Our Reference: 245005

The Consort, 36 The Ridgeway, Cuffley, EN6 4AX - NMA Application

We are pleased to submit, on behalf of Cavendo Holdings Ltd, an application under Section 96A of the Town and Country Planning Act 1990 (as amended) for non-material amendments to planning permission reference 6/2021/1649/VAR dated 6 August 2021. This NMA application relates to changes to the approved internal road layout and the erection of an entrance gate to the house in Plot 6.

<p>HFP Architects</p>	Client	CAVENDO HOMES	
	Job Title	CUFFLEY	
Chandos House Back Street Wendover Bucks HP22 6EB tel: 01296 625995 fax: 01296 622617 e-mail: info@hfparchitects.co.uk	Drawing Title	PROPOSED ACCESS GATES SITE PLAN	
	Date	June 22	Scale 1:250
	Job no	3356	
	Drawing No	PD401	Rev.

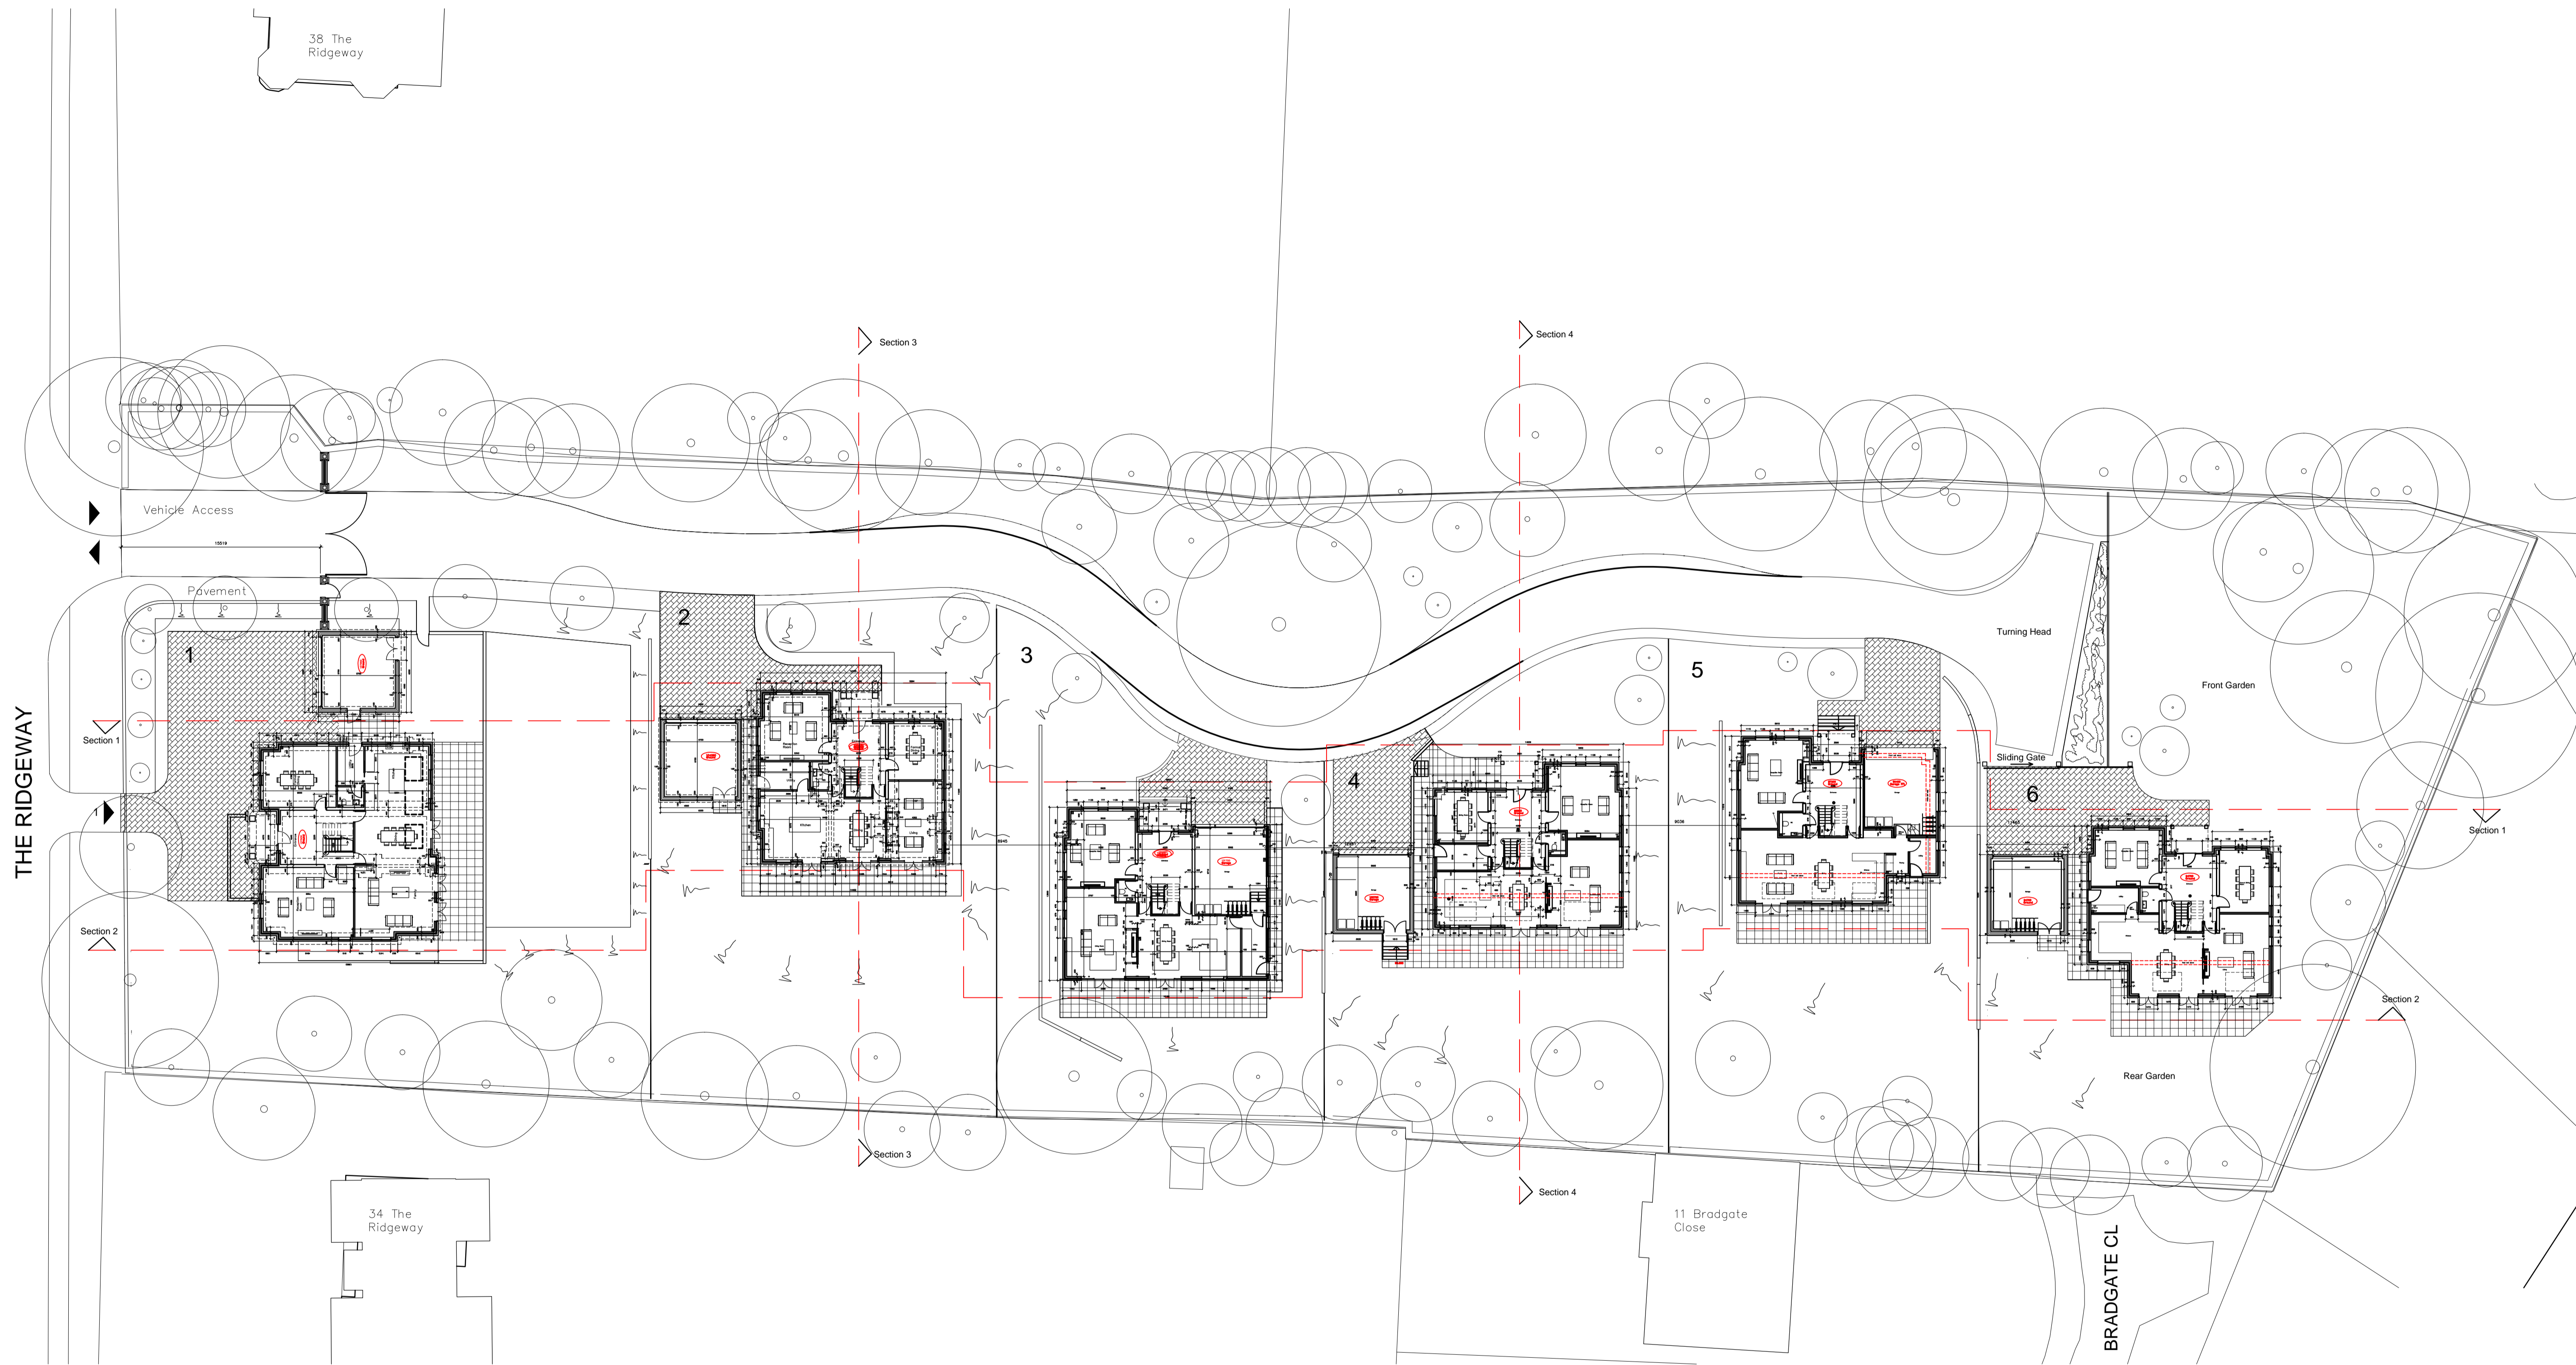
Our client is now seeking the council to agree a non-material amendment to planning permission 6/2021/1649/VAR to modify the internal road layout at the northern end and install a gate for the house on Plot 6.

The proposal seeks to modify the end of the internal road to change it to a hammerhead rather than the previous arrangement. House No.6 would also have a new gate into their parking area as shown on Drawing PD401 below.

Client	CAVENDO HOMES					
	Job Title	CUFFLEY	Date	08.22	Scale	NTS	
Chandos House Back Street Wendover Bucks HP22 6EB tel: 01296 625995 fax: 01296 622617 e-mail: info@hfparchitects.co.uk	Drawing Title	COMPARISON SITE PLANS		Job no	3356		
				Drawing No	PD402	Rev.	B

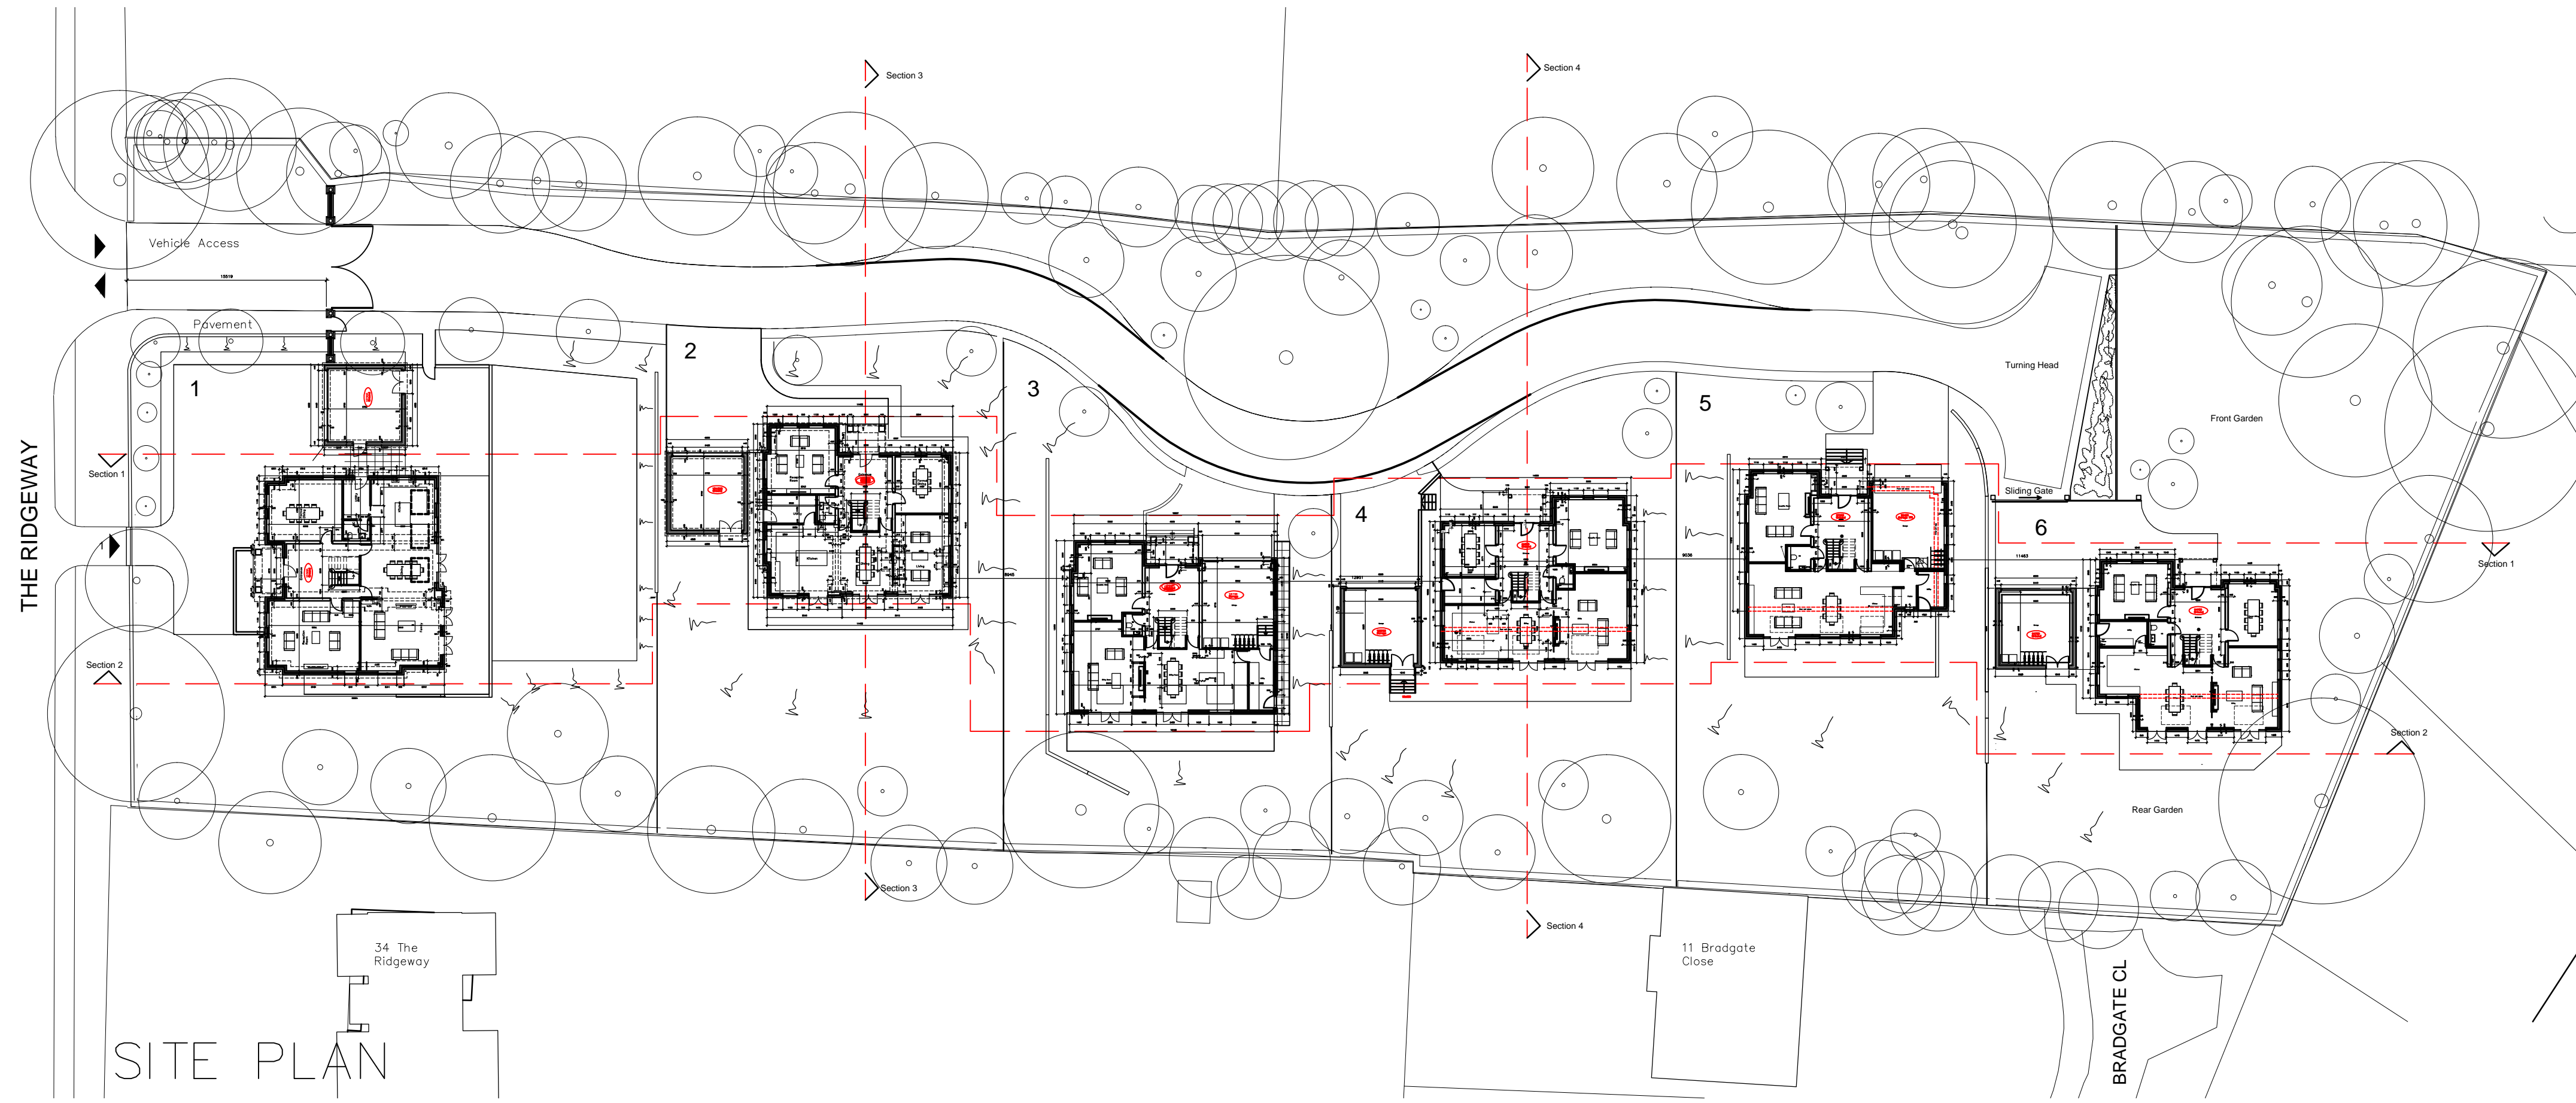
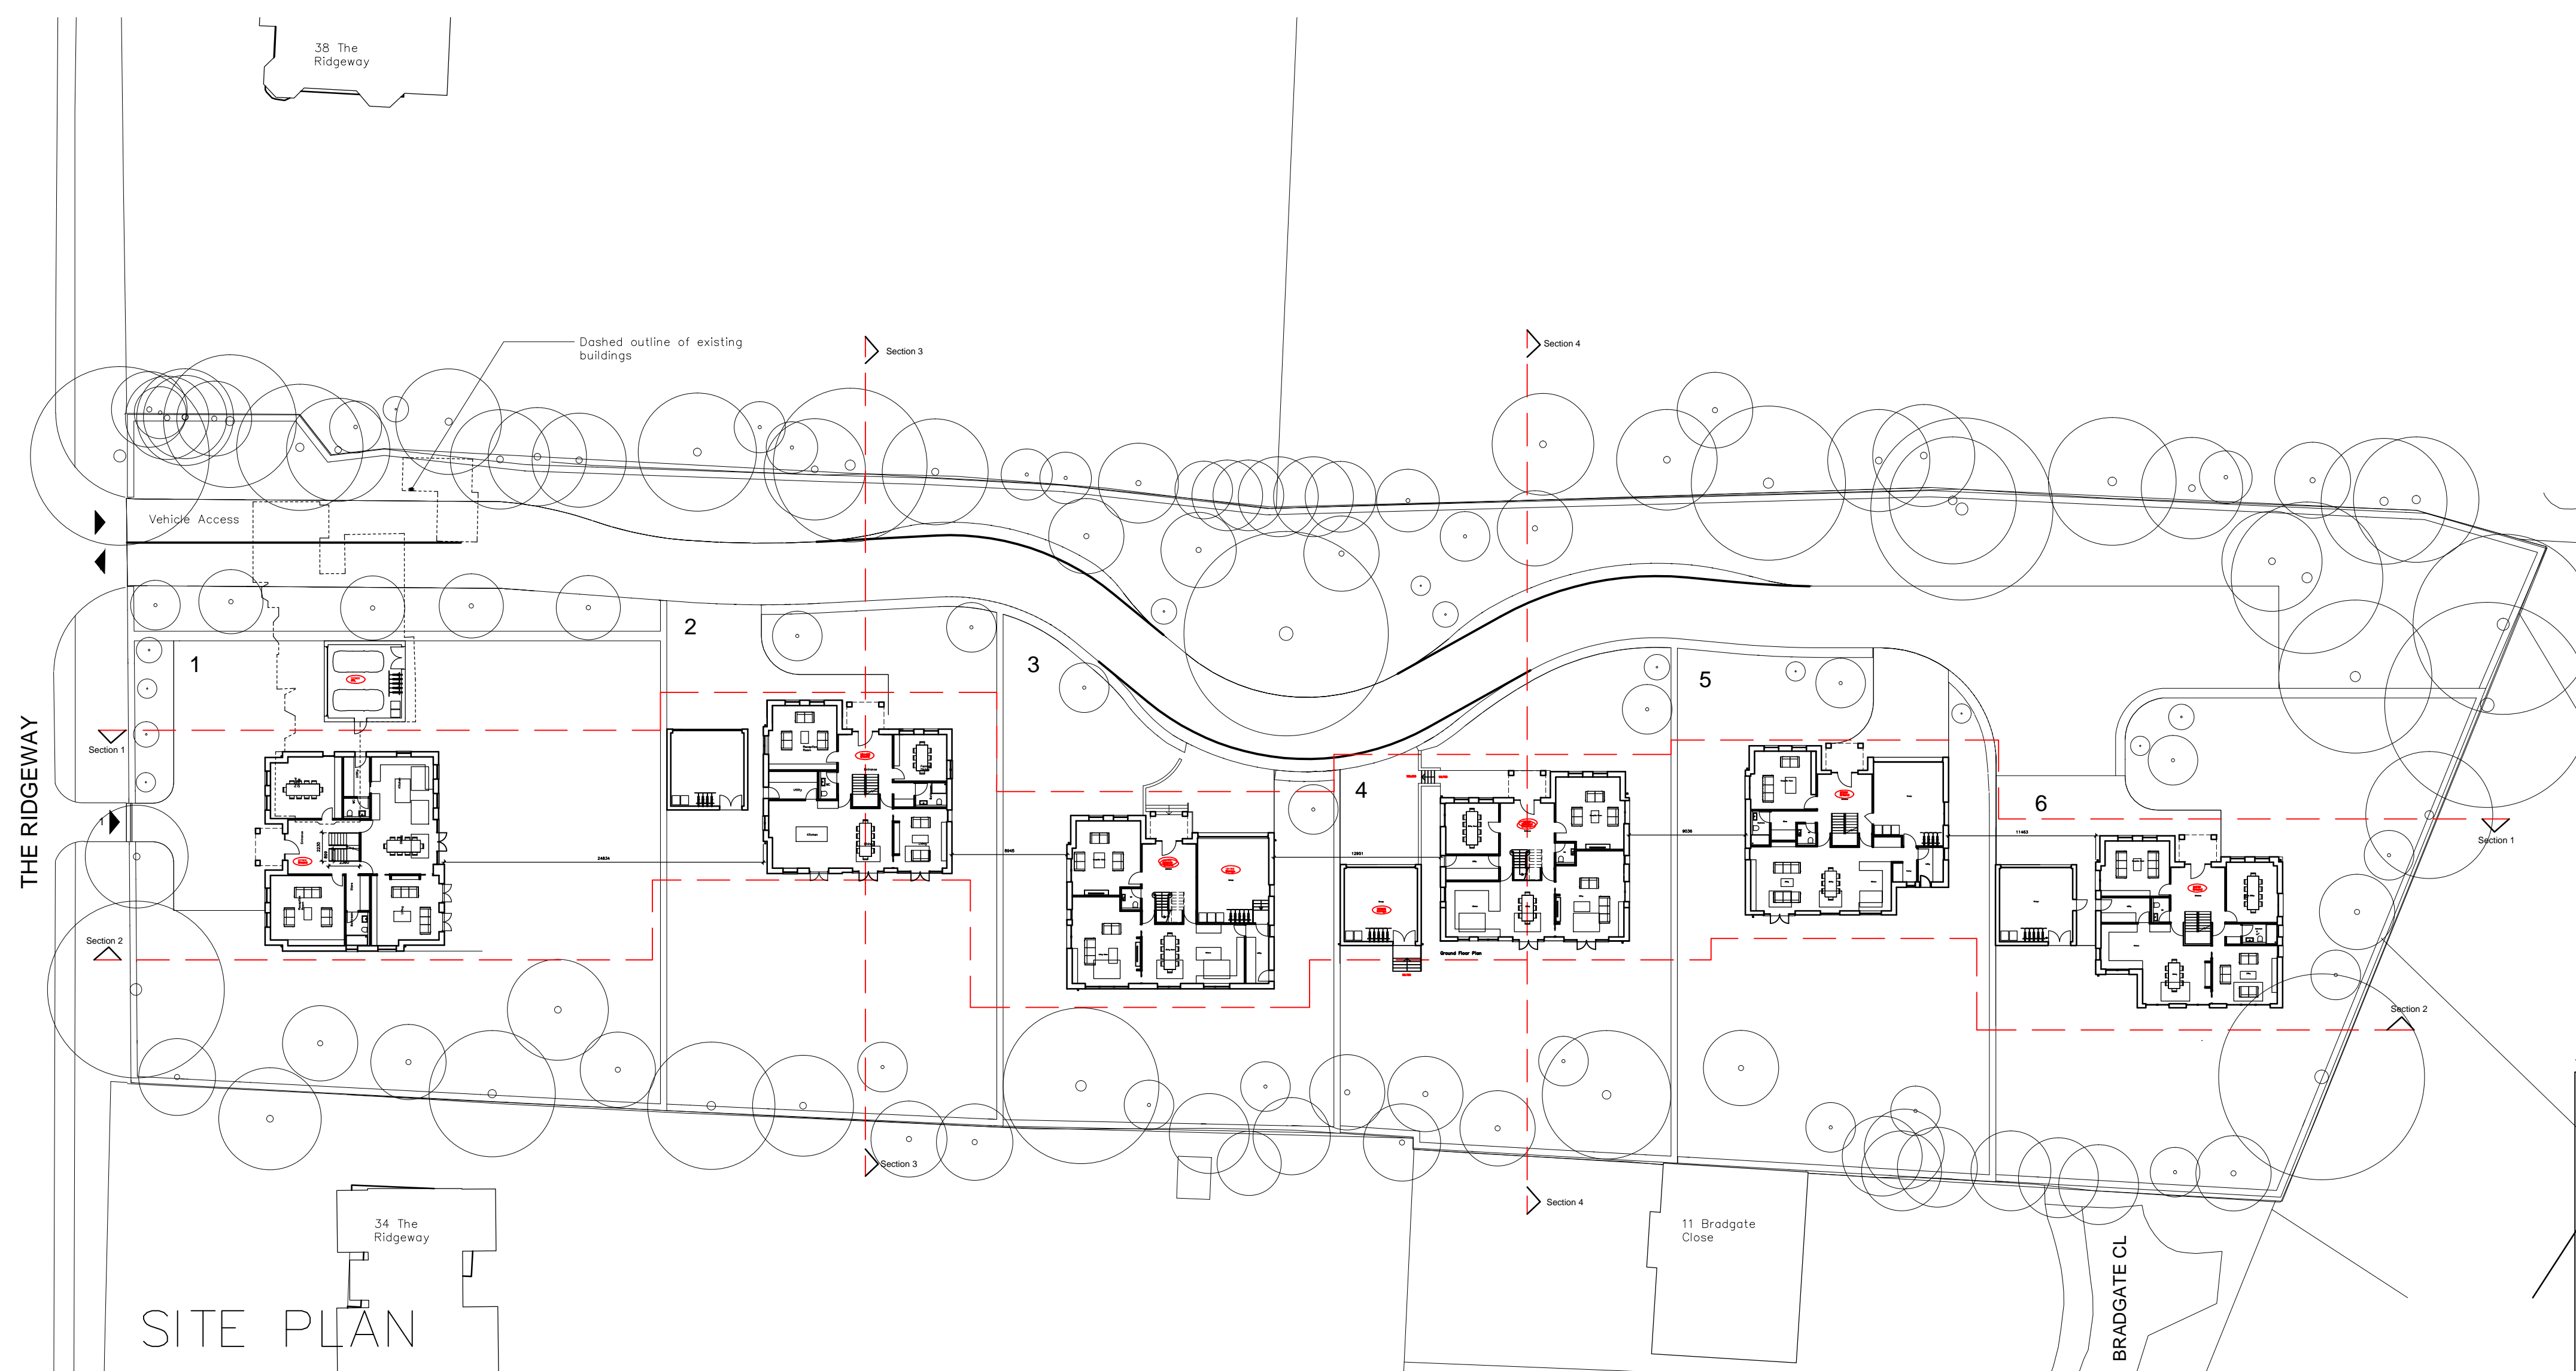
Drawing Title	Approved drawing ref (6/2021/1649/VAR)	Proposed NMA drawing ref
Proposed Site Plan	PD100/B	PD401
Comparison Site Plan	PD111	PD402/B
Proposed Block Plan	PD113	PD403
Proposed Gate Elevations	n/a	PD404
